HUNTER'S HILL COUNCIL

Enquiries: SSD 17-8970

Development Application No. SSD 17-8970
Premises St. Joseph's College, Mark Street Hunters Hill

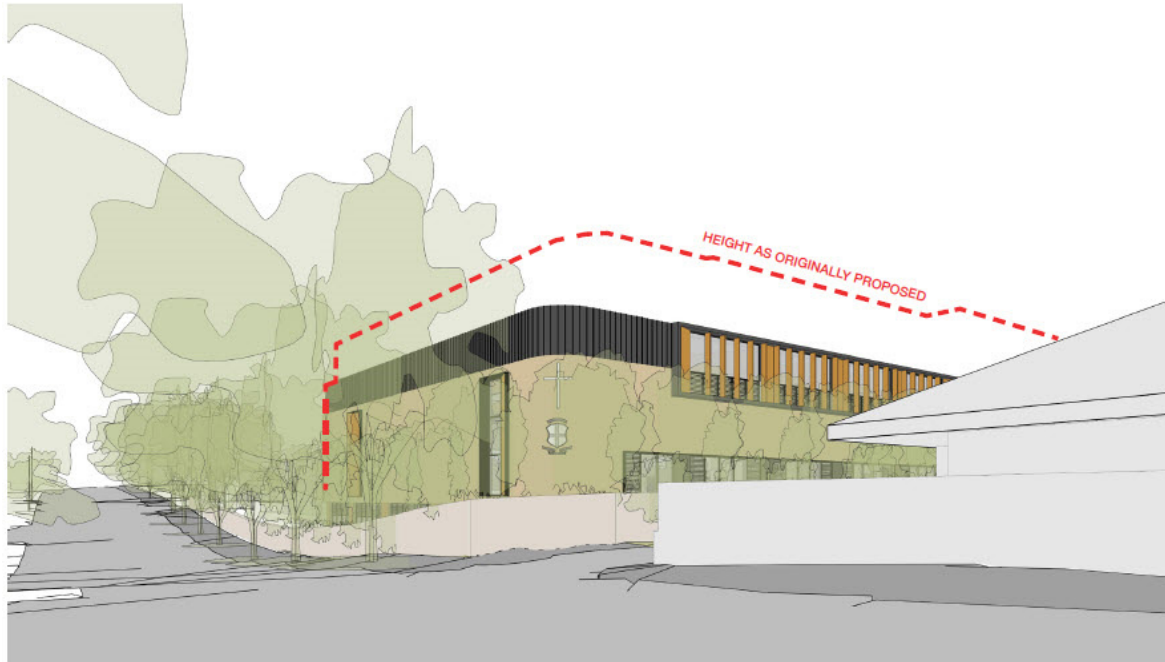
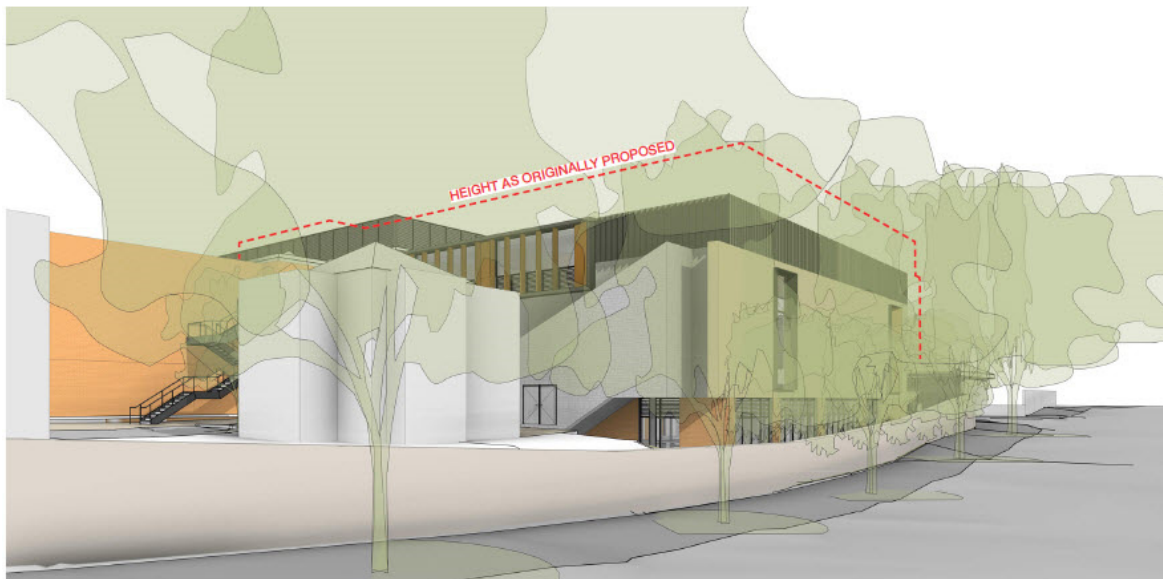
- The size and scale of this new sports building so close to Luke Street will be detrimental to this part of the local streetscape when compared to the low scale residential development opposite in the Low Density Residential R2 zoned area.

- The likely character of the new sports building will be such as to introduce a new architectural element not in sympathy with the low scale dwelling houses opposite in this part of Luke Street.
